From: Contact Centre (CRM) <contact@ribblevalley.gov.uk>
Sent: 17 May 2022 16:57
To: Planning
Subject: Planning Application Comments - 3/2022/0421

Planning Application Reference No.: 3/2022/0421

Address of Development: 21 Paris, Ramsgreave.

PROPOSED NORTH EAST ELEVATION (FRONT). SCALE 1:100

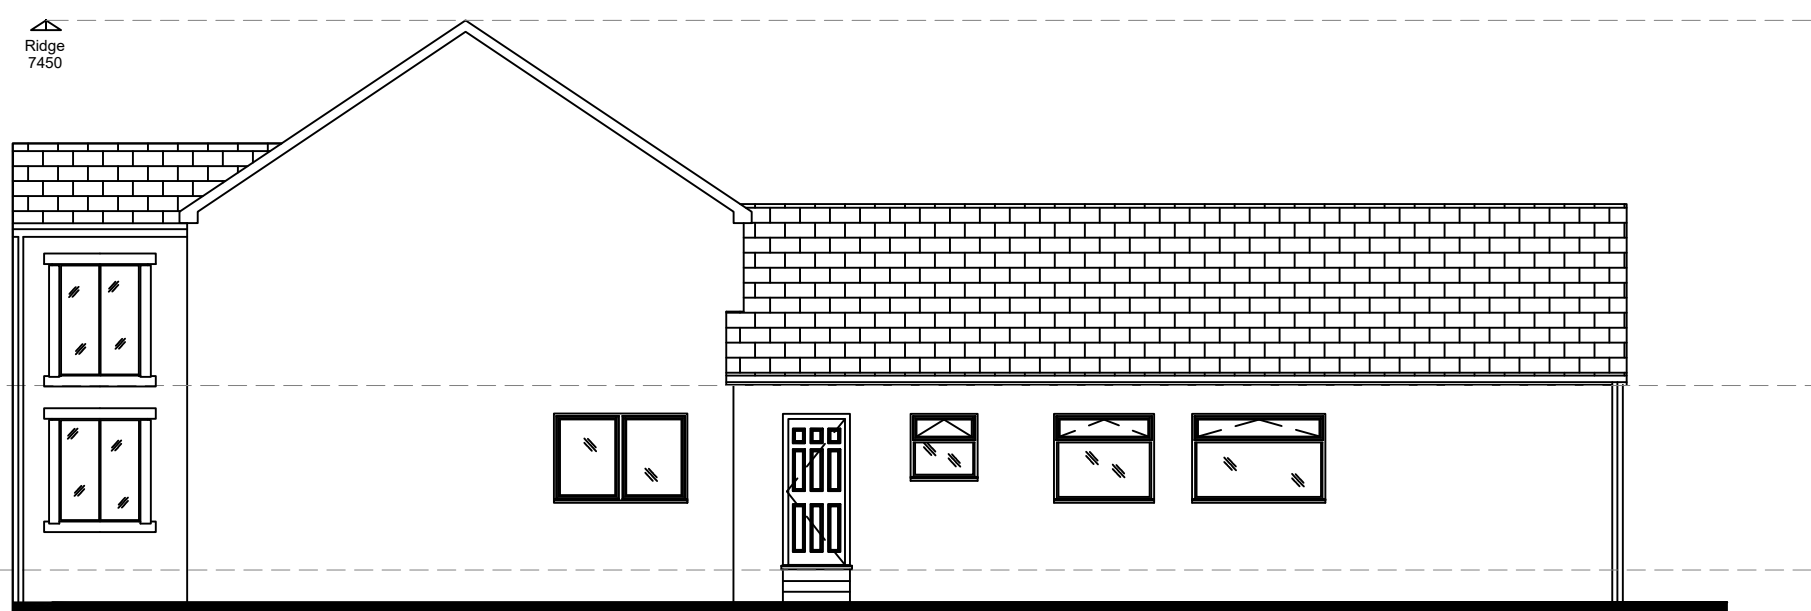
Comments: I do not object to the change to the porch structure at the front of the development. I do object to the insertion of the roof lights to the front of the dwelling and at the rear. They will have a significant impact on the

PROPOSED SOUTH WEST ELEVATION. SCALE 1:100

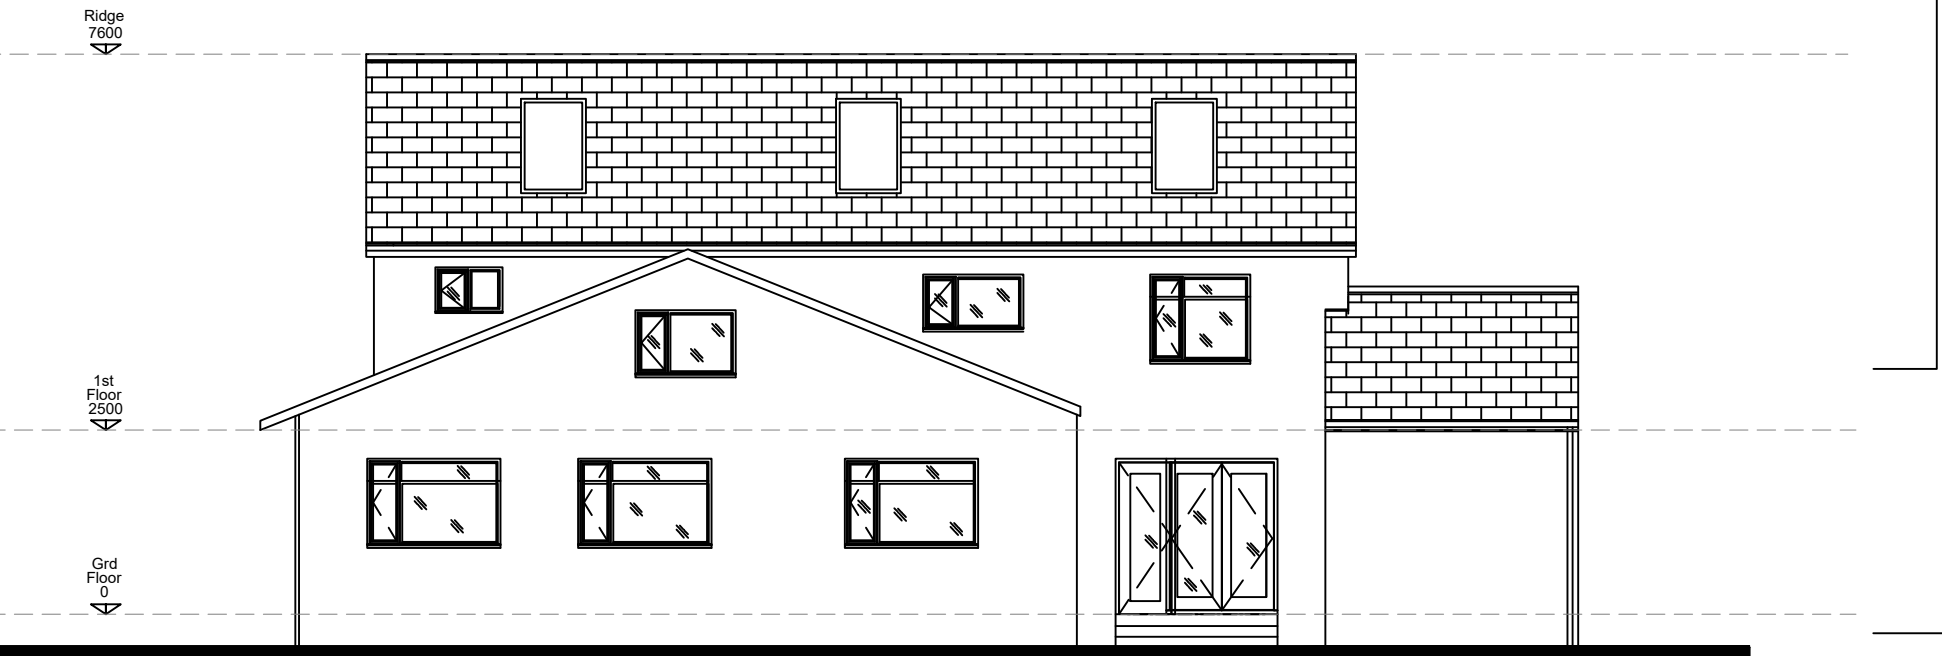
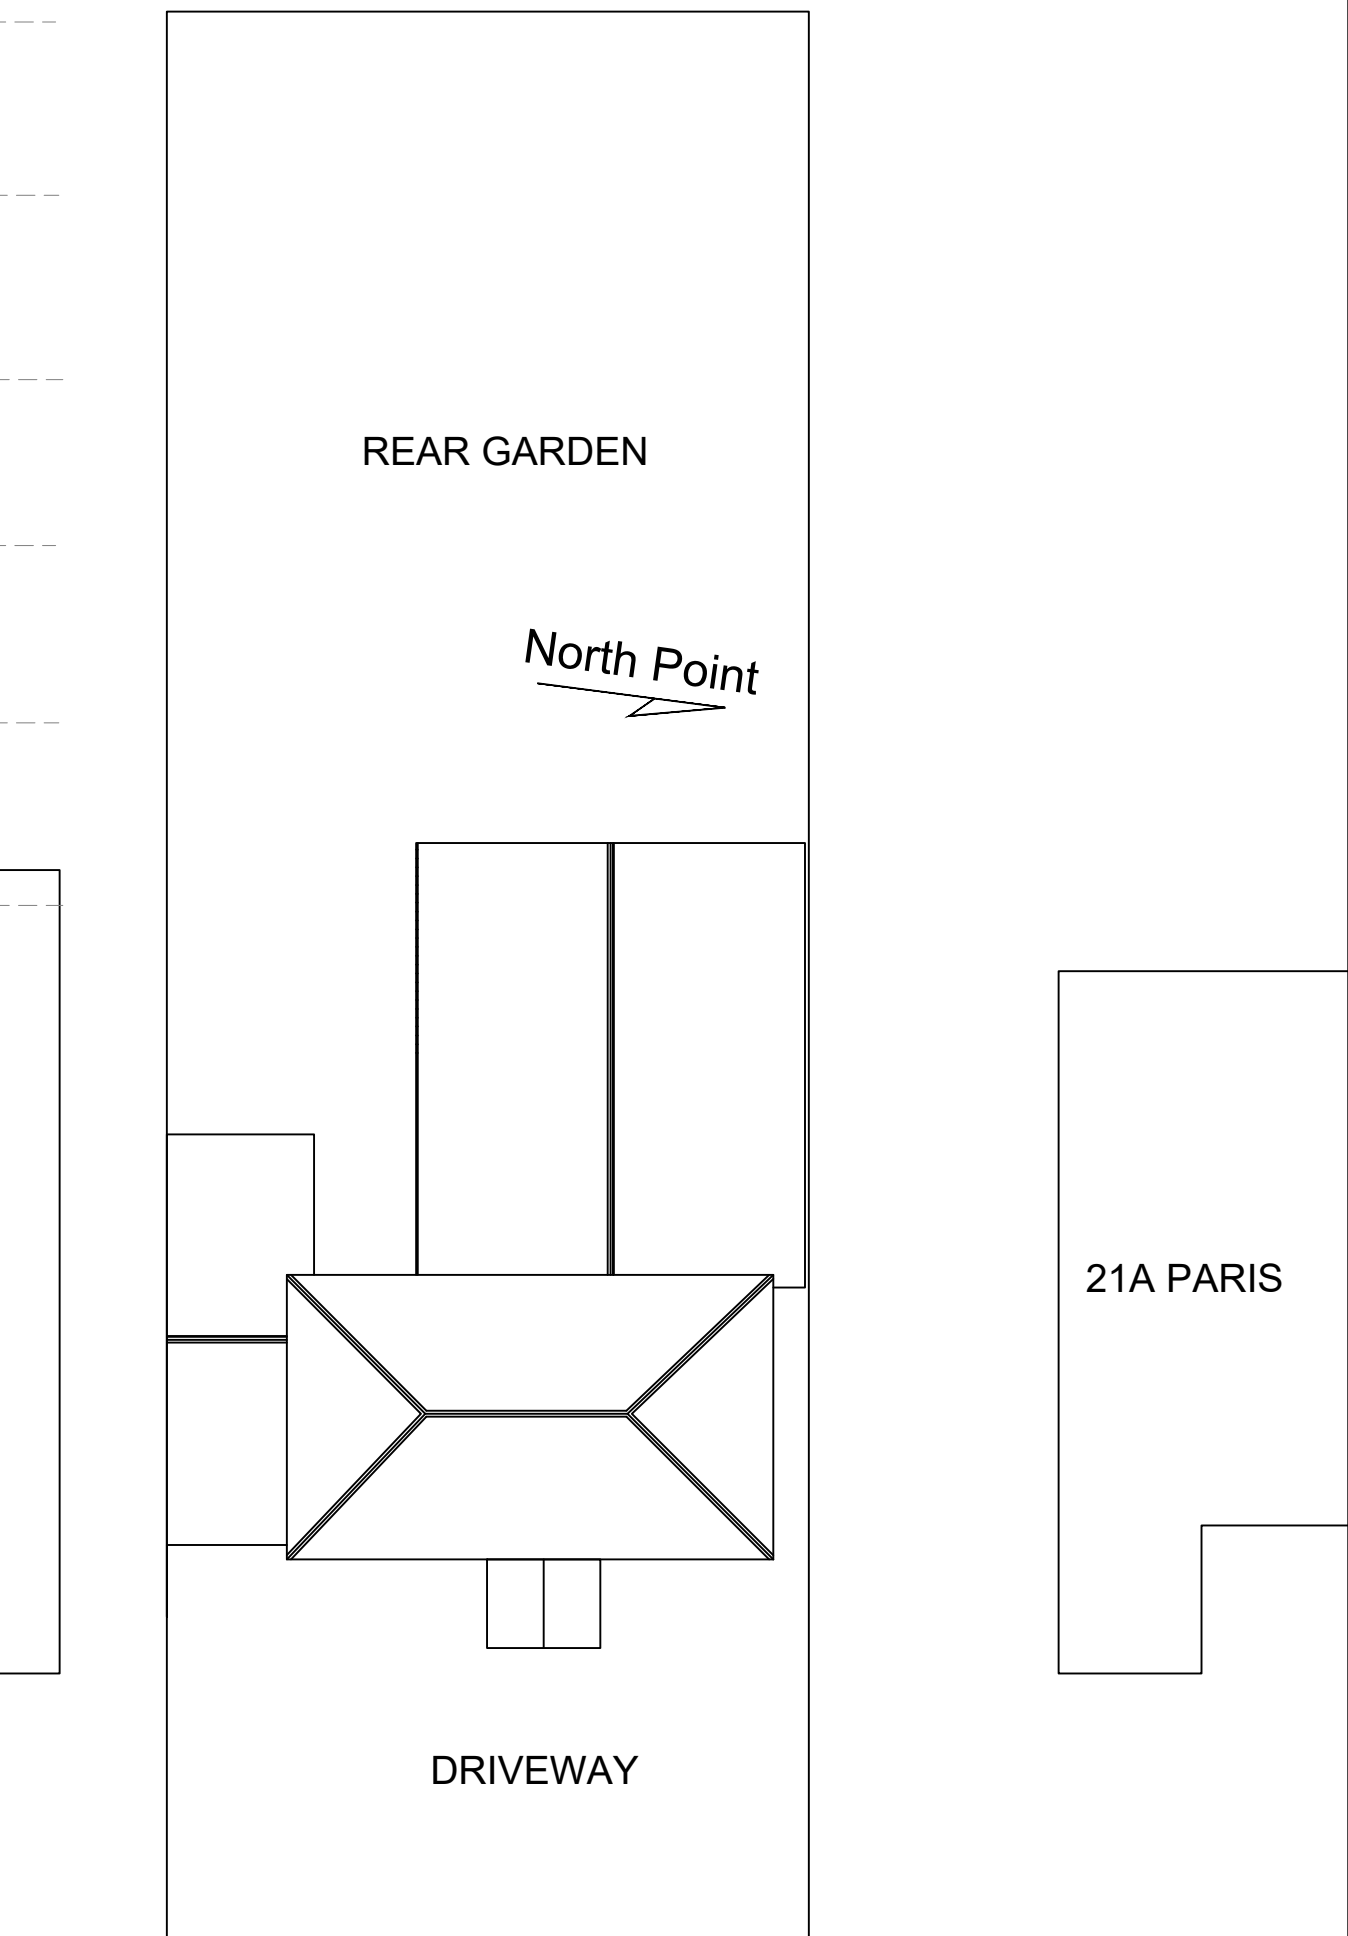
[REDACTED] The roof lights at the rear will also have a huge impact to [REDACTED] and will again [REDACTED]

PROPOSED BLOCK PLAN (MINOR MODIFICATION TO CURRENT)

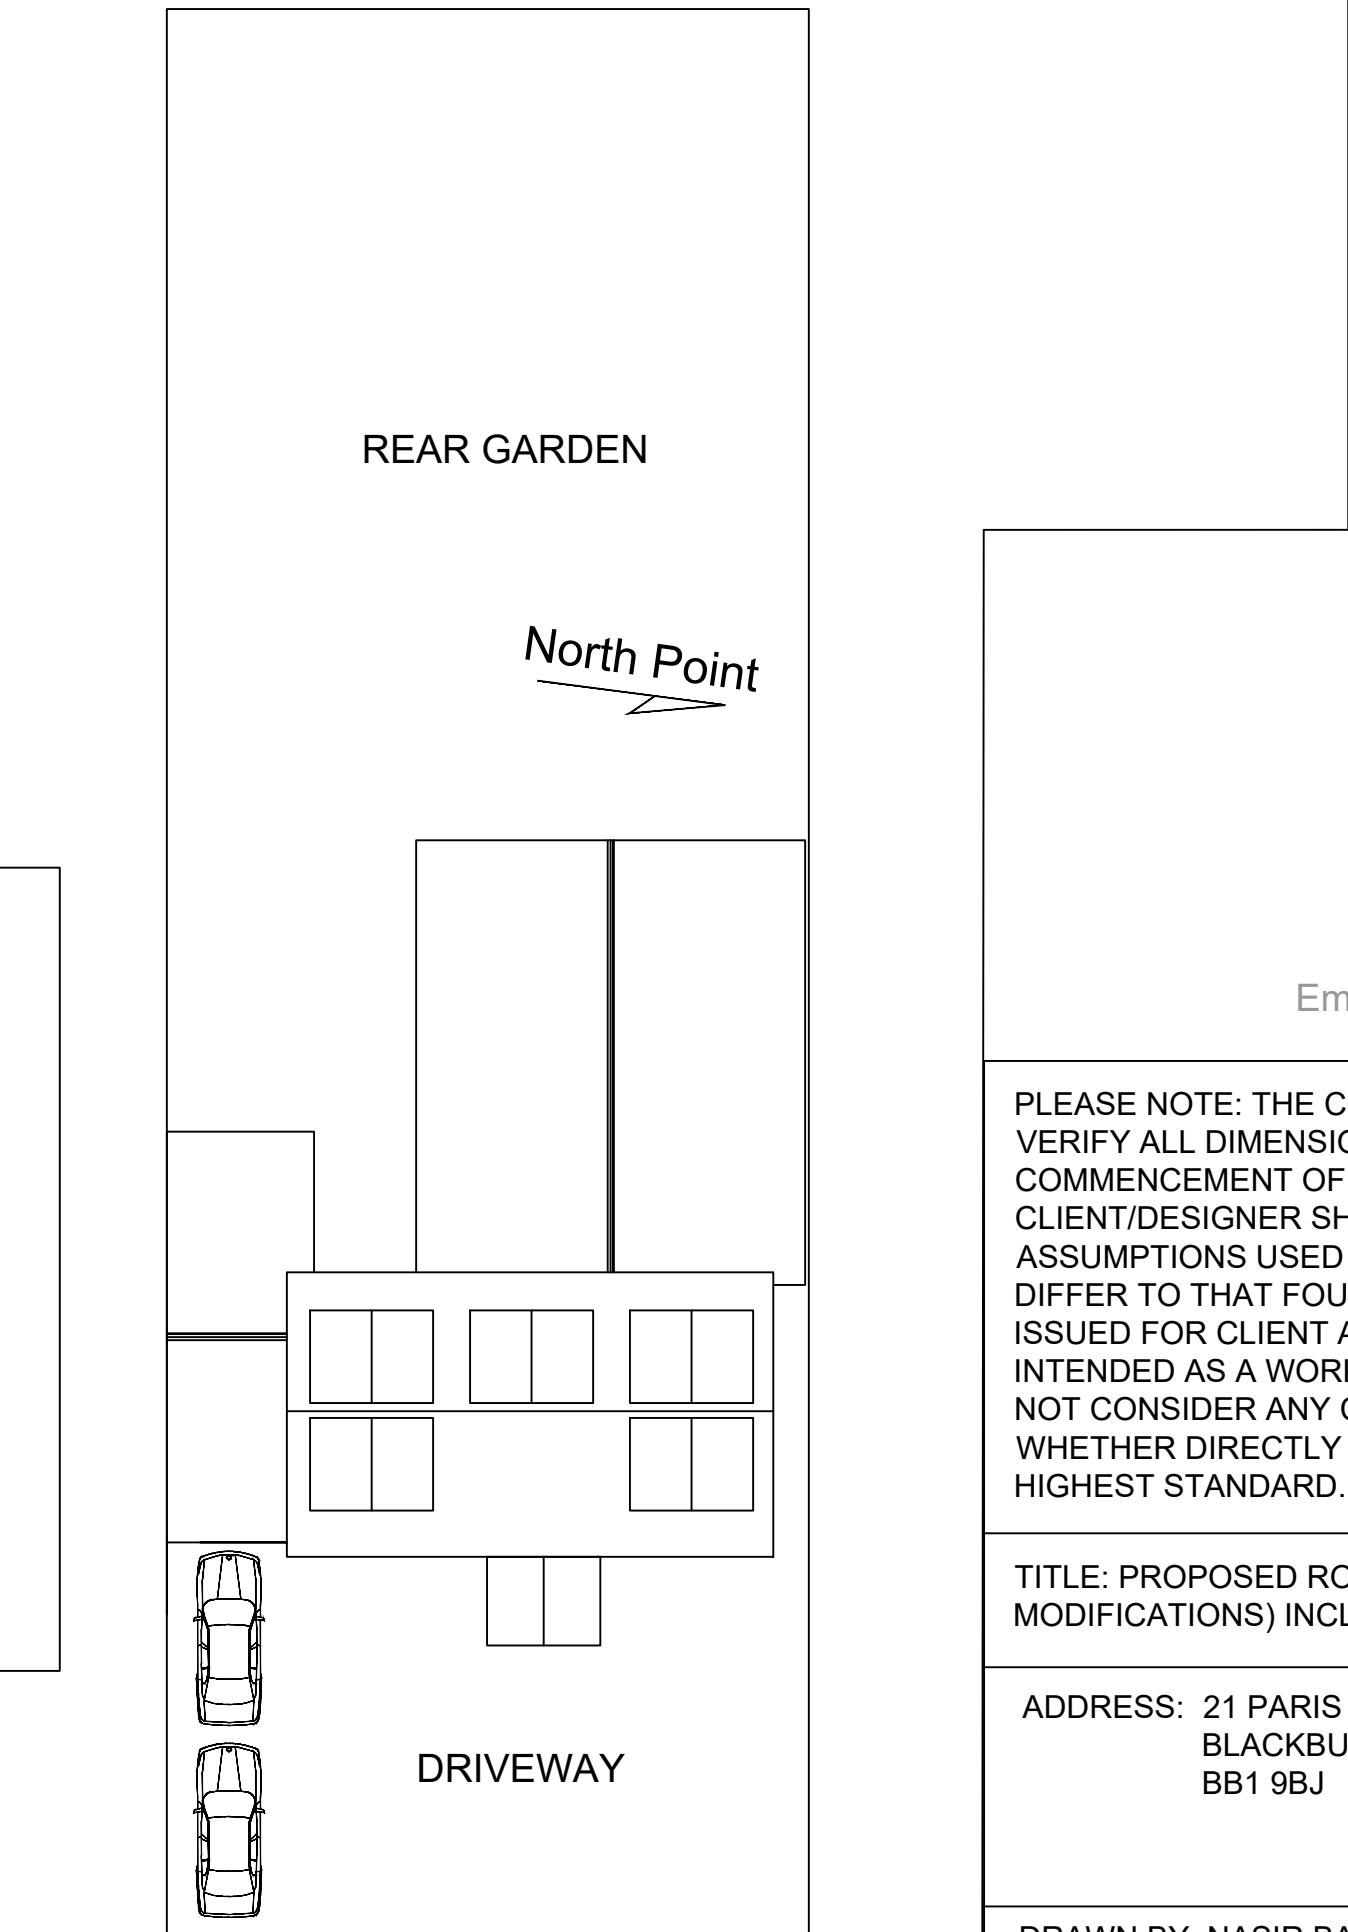
[REDACTED] I would also query why the roof lights are required in storage areas of the new development and again I suspect the applicant is again misleading the authority and that these will areas will obviously be additional bedrooms. The plans are again inaccurate and once again show the garage of the new build being built directly at the boundary wall when it should be 90 cm away to ensure they do not cause further damage.
